Application Ref:	3/2026/0281			 Ribble Valley Borough Council www.ribblevalley.gov.uk
Date Inspected:	24/04/26	Site Notice:	24/04/26	
Officer:	LW			
DELEGATED ITEM FILE REPORT:				APPROVAL

Development Description:	Demolition of existing dwelling and erection of one replacement self-build dwelling with garage and associated garden curtilage, hard and soft landscaping, new access drive off Longsight Road and the closure of the existing access.
Site Address/Location:	Bridgecroft, Longsight Road, Copster Green, BB1 9EX.

Sheet Name:
PROPOSED LOWER GROUND AND
GROUND FLOOR PLANS

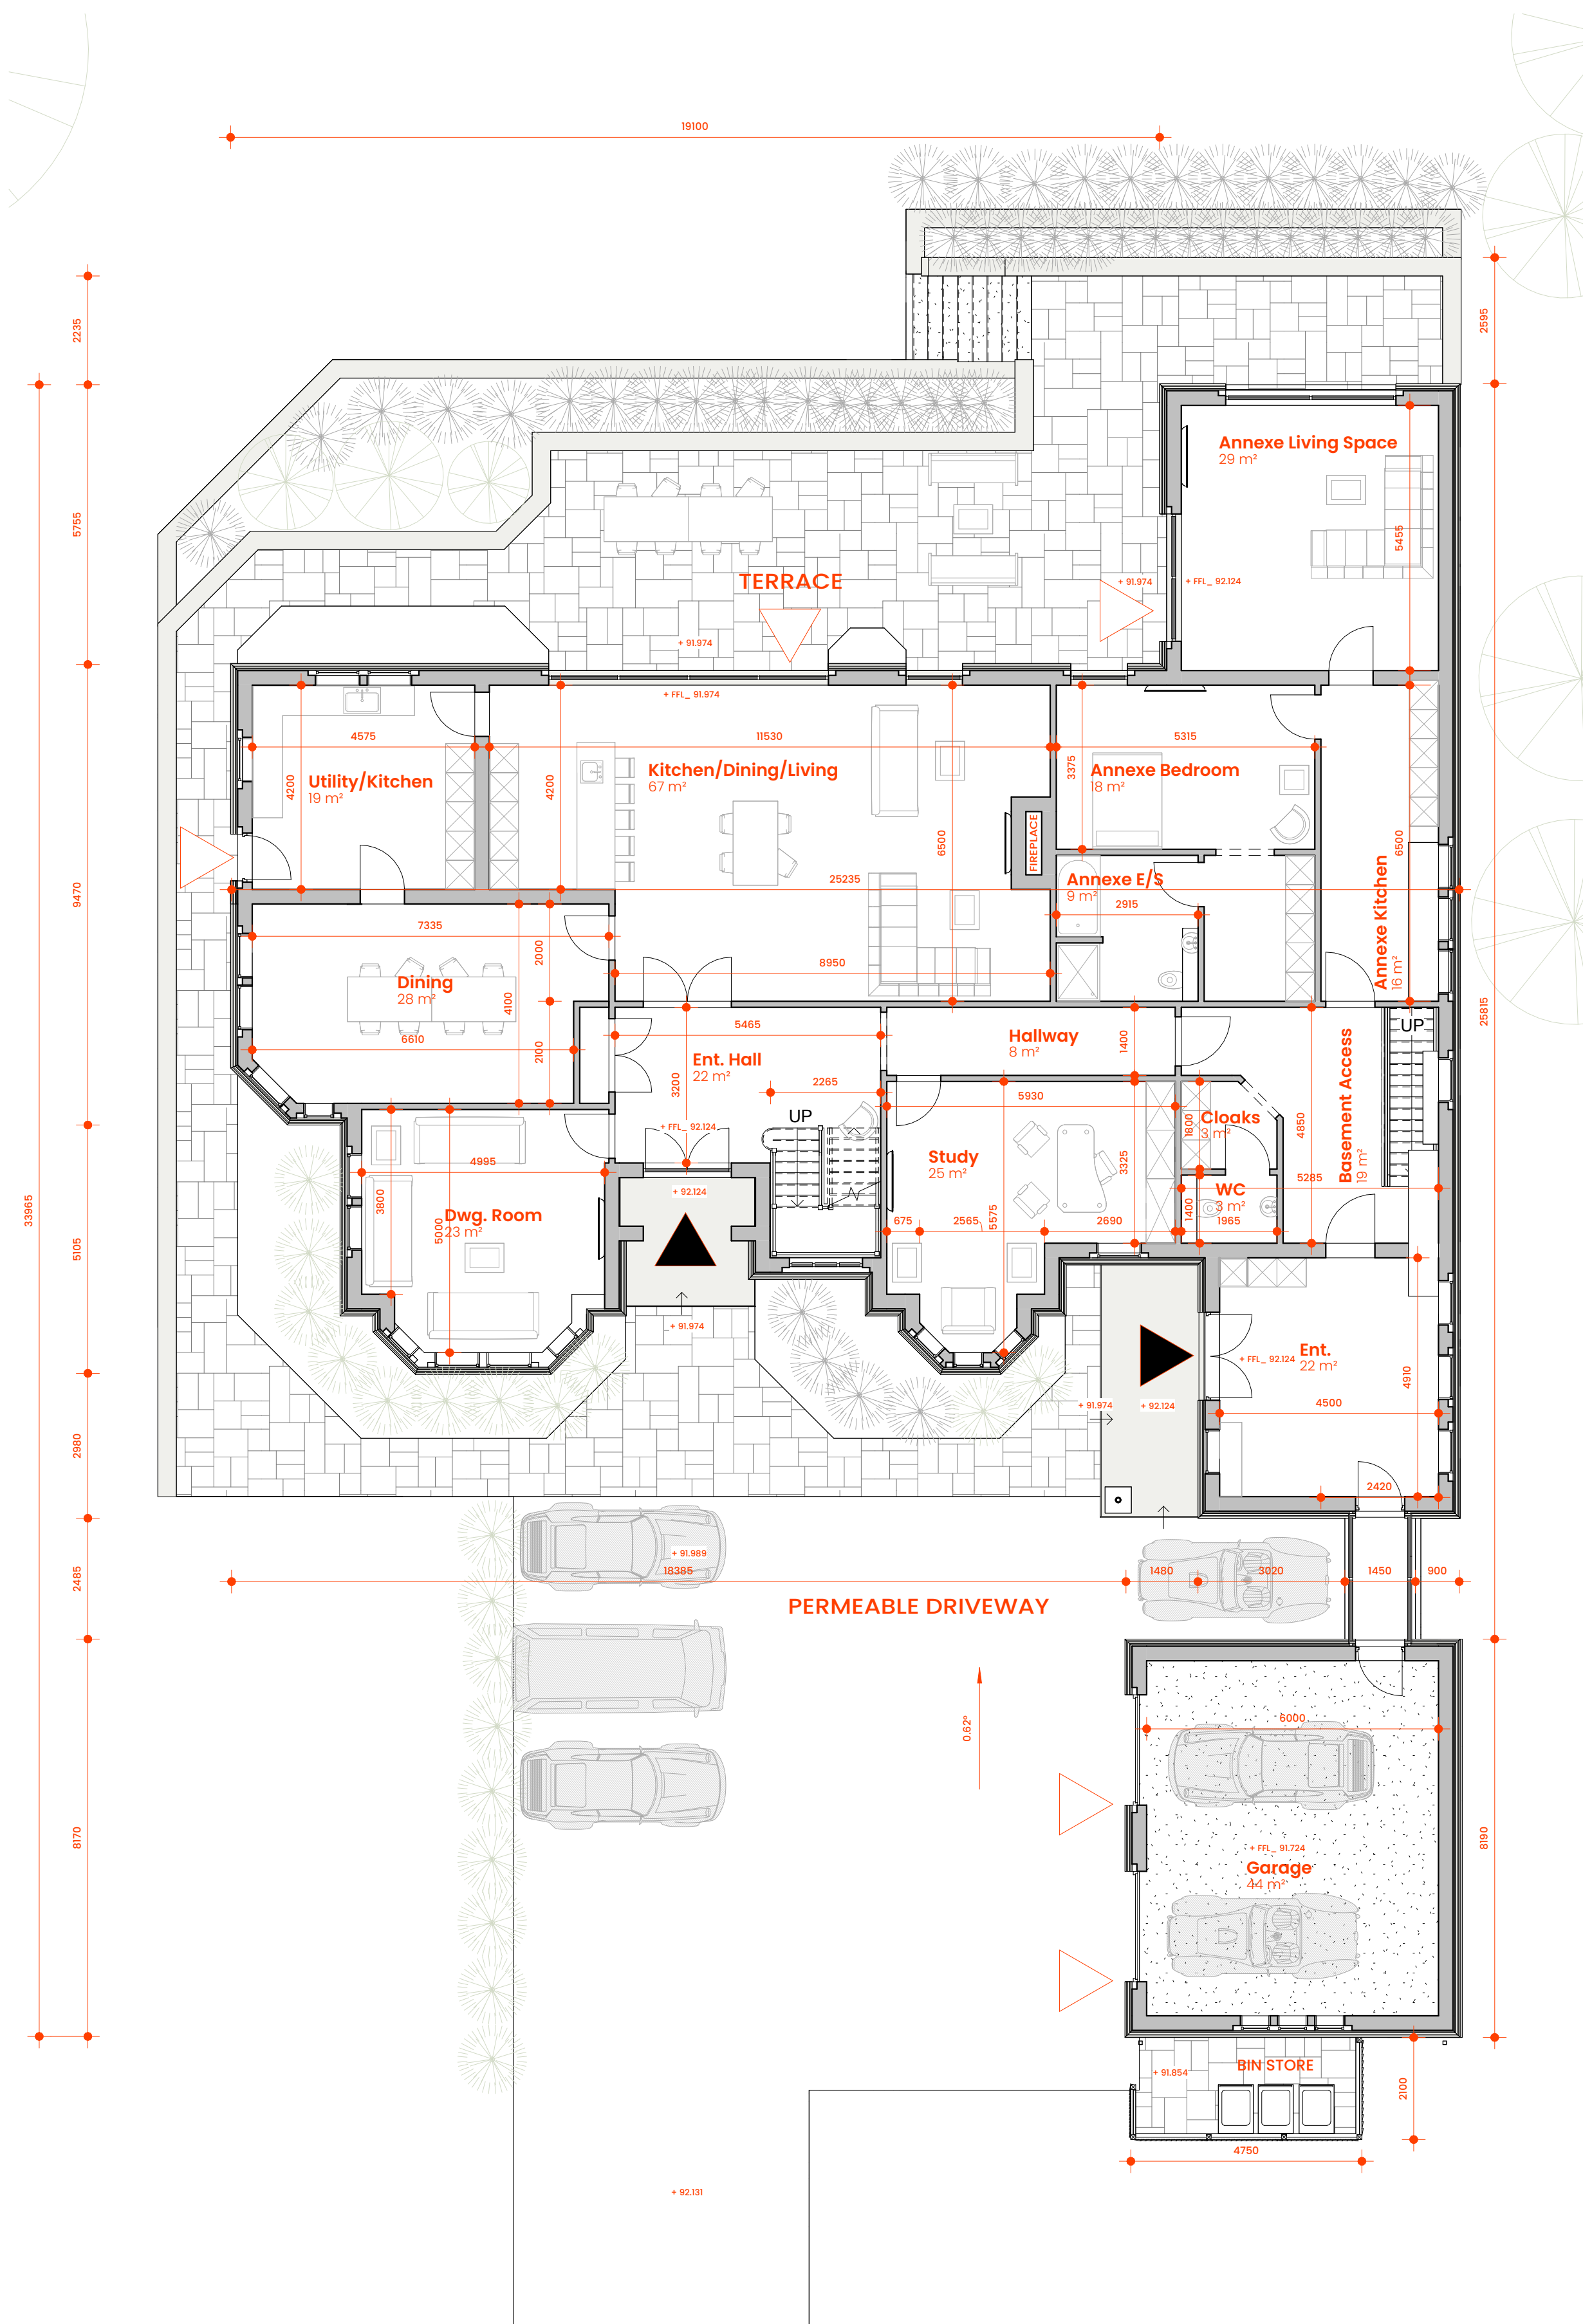
Whilst it was acknowledged that the site benefits from a degree of visual screening from existing vegetation, concerns were raised regarding the scale and massing of the replacement dwelling, particularly the three-storey rear elevation. Given the land levels fall away to the rear of the site, it was considered that the development would appear particularly prominent from wider viewpoints, including Ribchester Road and the Public Rights of Way to the north.

Following discussions with the applicant, amendments have been made to reduce the prominence of the dwelling, particularly when viewed from the rear. The footprint of the building has been moved forward towards Longsight Road, where ground levels are higher, and both the finished floor levels and overall height of the dwelling have been reduced. Consequently, the lower ground floor would now function as a

basement level, with the previously proposed three-storey glazed feature to the rear elevation subsequently reduced to two storeys. The terraced patio has been revised and would extend across the full width of the dwelling, gradually stepping down from the finished ground floor level to the natural slope of the rear garden. Collectively, these amendments have significantly reduced the overall scale, massing and visual impact of the rear of the dwelling.

2 PROPOSED SITE PLAN - PLANNING
1: 500

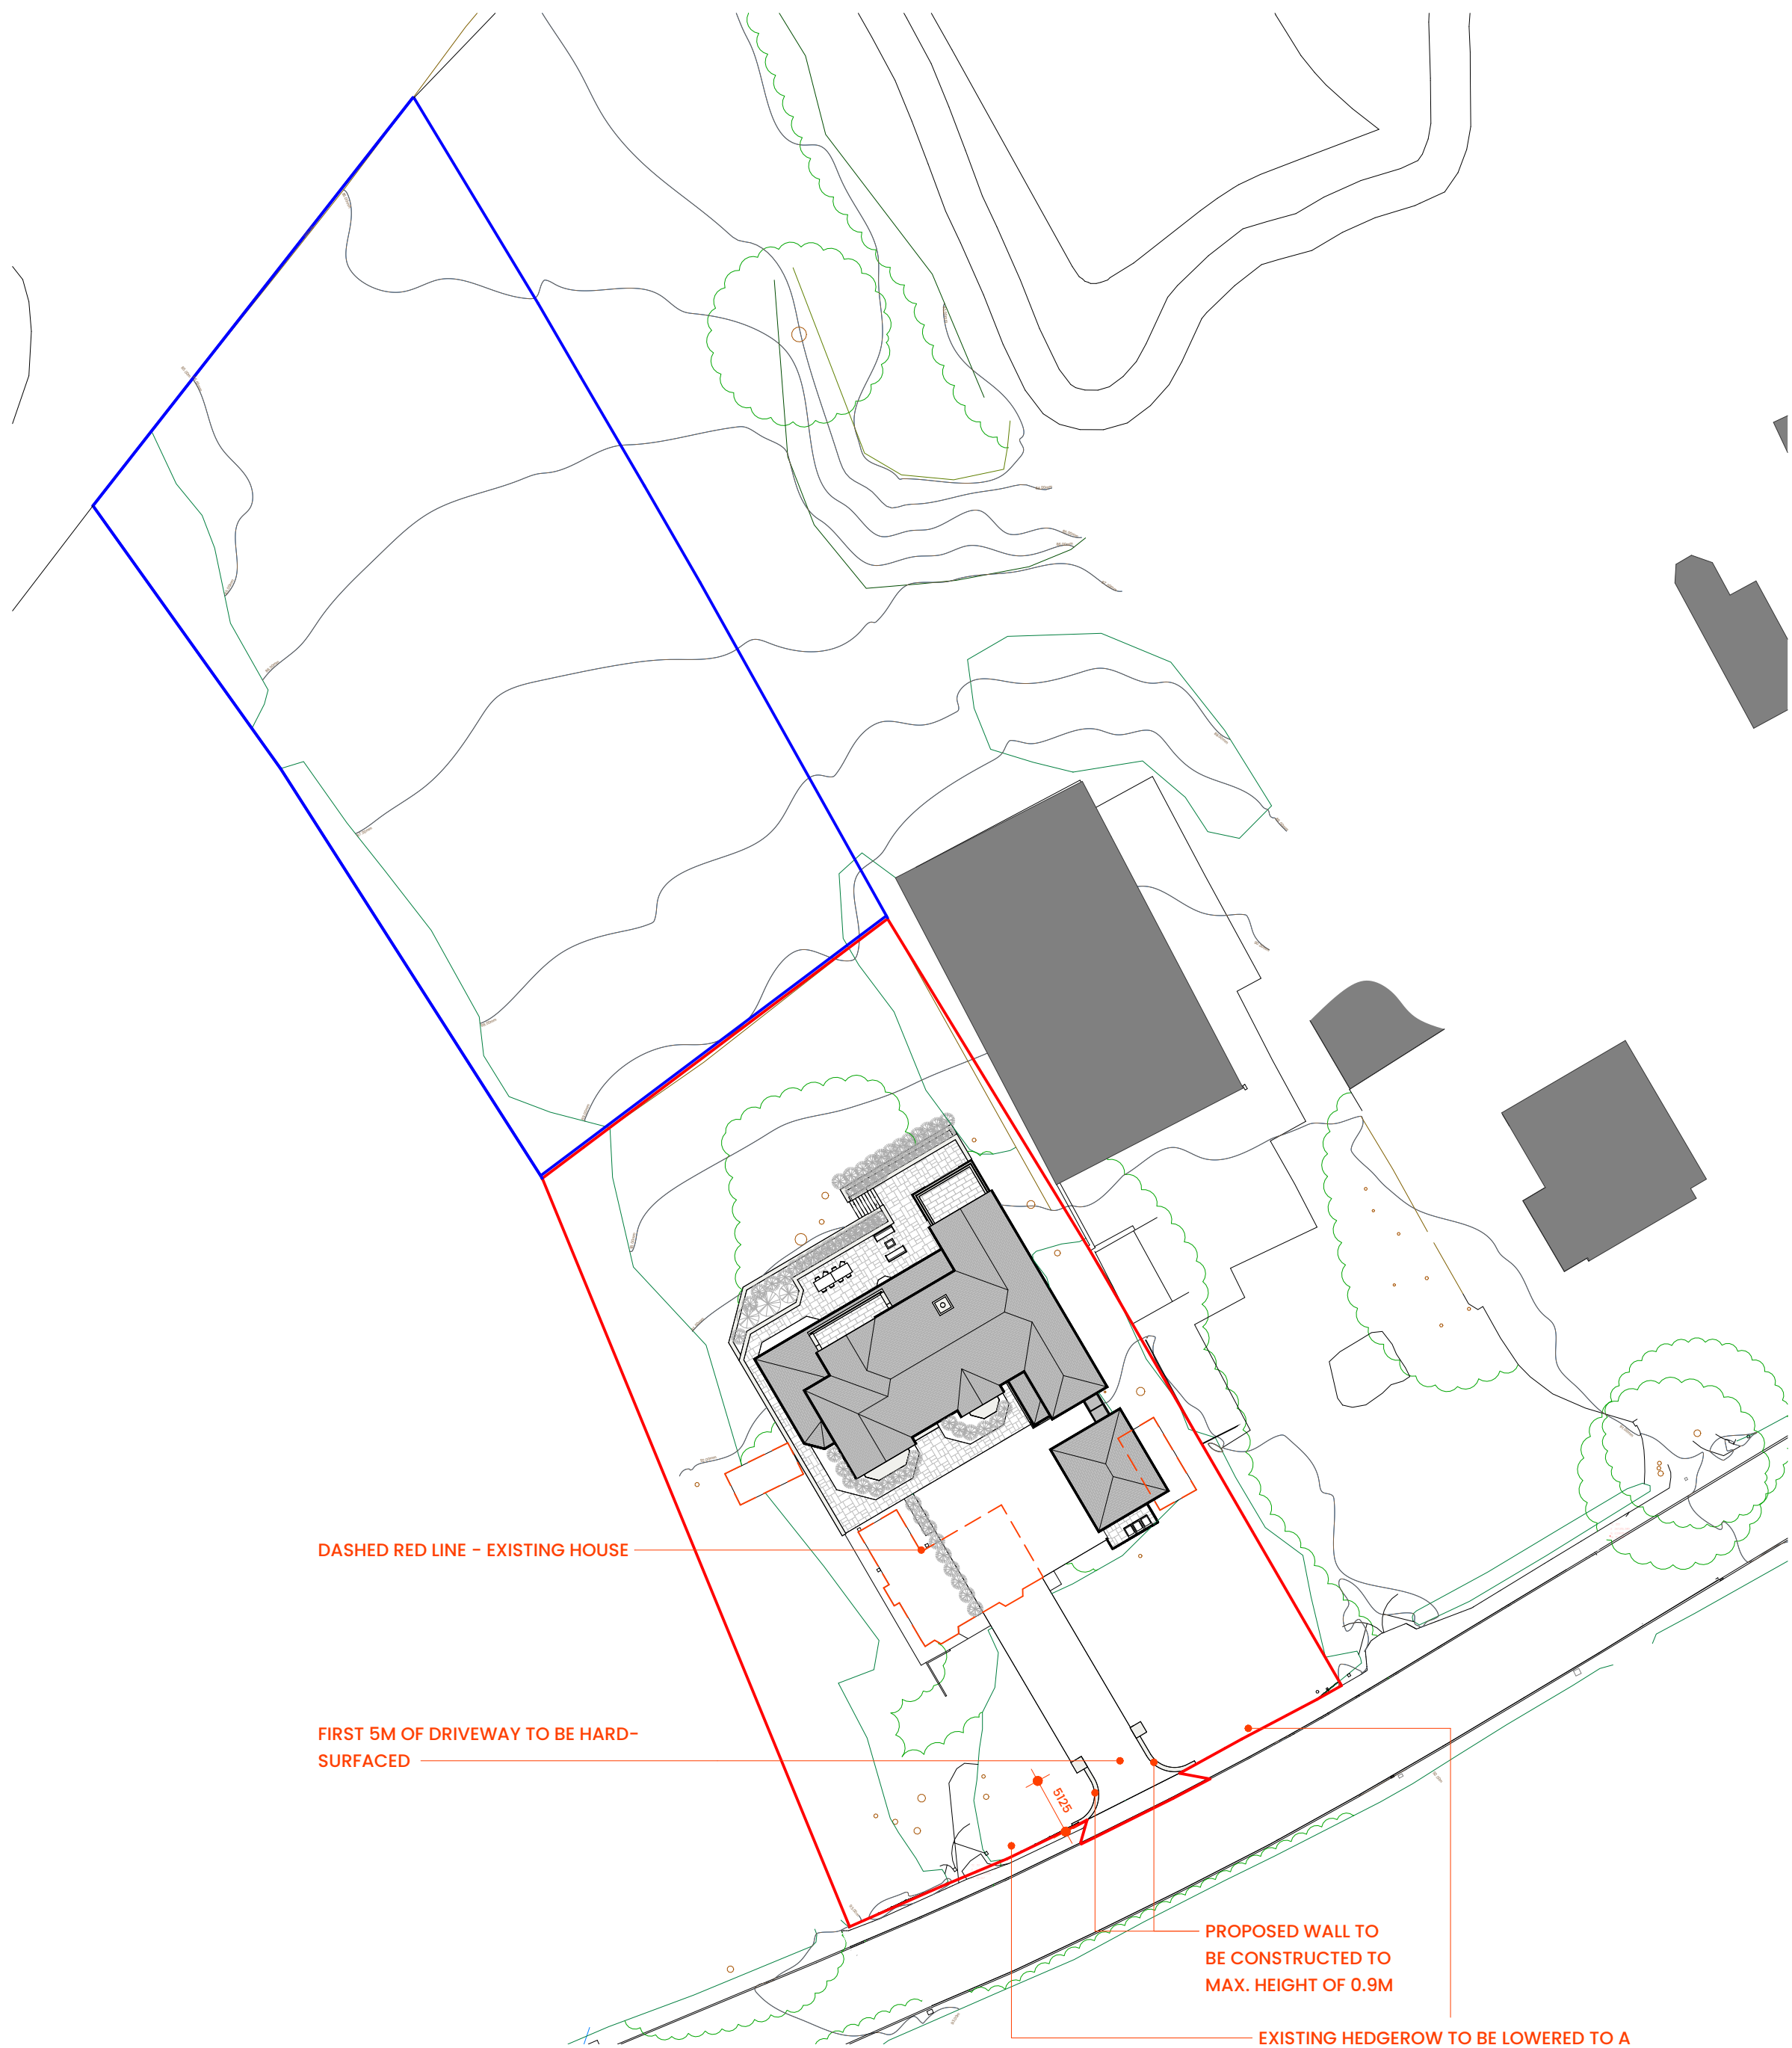
In their initial consultation response, the Local Highway Authority (LHA) advised that insufficient information had been submitted to enable a full assessment of the development's impact on the surrounding highway network and its users. In particular, the application failed to demonstrate that adequate visibility splays could be achieved from the proposed new access onto Longsight Road (A59), a two-way classified road subject to a 40mph speed limit and carrying a high volume of traffic.

No details of visibility splays had been provided with the application and whilst the proposed re-location of the access to a more central position within the plot would likely improve visibility compared to the existing access, it remained necessary to demonstrate that appropriate splays could be achieved.

The Highway Authority also raised concerns about the width of the access, advising that the first 5m of the access should be a minimum width of 5m to allow two vehicles to pass, thereby preventing vehicles from waiting on the carriageway.

In response to these concerns, the applicant submitted additional information, including an amended site layout plan, visibility splay drawings and supporting correspondence from Focus Transport Planning.

The submitted information has subsequently been reviewed by the LHA. The Authority notes that the proposed access has been amended to provide a width of 5 metres for the first 5 metres measured from

the back edge of the footway and confirms that the revised access arrangement is acceptable from a highway safety perspective.

The LHA has also reviewed the visibility splays demonstrated on the submitted drawings and considers them to be acceptable. Whilst the achievable visibility splay to the right on exit from the site falls short of the full 120-metre requirement, the visibility available would represent a notable improvement over the existing situation. Given this enhancement, the LHA is satisfied that a departure from the standard requirement can be accepted in this instance.
